Technical Memorandum: Review of HIA for Development of Land at Eastfield, Submitted by Banks Group Ltd for Planning Application 2025/60/92776/E.

Date: November 6th, 2025

Subject: Review of hydrogeological impact assessment for proposed residential development

Figure 3-4 Recorded Rest Water Levels in mAOD

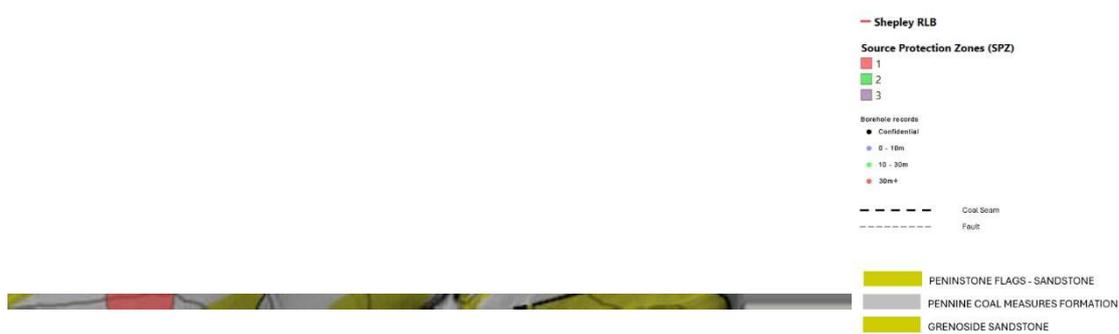
33	Figure 3.4	Figure not clear	The figure is unclear and cannot be reviewed	Provide a clear figure
34	3.9	No discussion of groundwater quality importance to Shepley Spring	No local groundwater quality data was collected. Baseline monitoring is essential as is recognition of regulations around Natural Mineral Waters	A more detailed, quantitative HIA is required before any planning decision is made.
35	3.10	Black Shale formation described as a confining layer	This has not been established by Banks through investigative work and is an assumption.	A more detailed, quantitative HIA is required before any planning decision is made.
36	4.1	The outline plan is given to set the principle of development	A decision on the principle of development cannot be made at this stage given the vulnerability of groundwater users within a SPZ1	A more detailed, quantitative HIA is required before any planning decision is made.
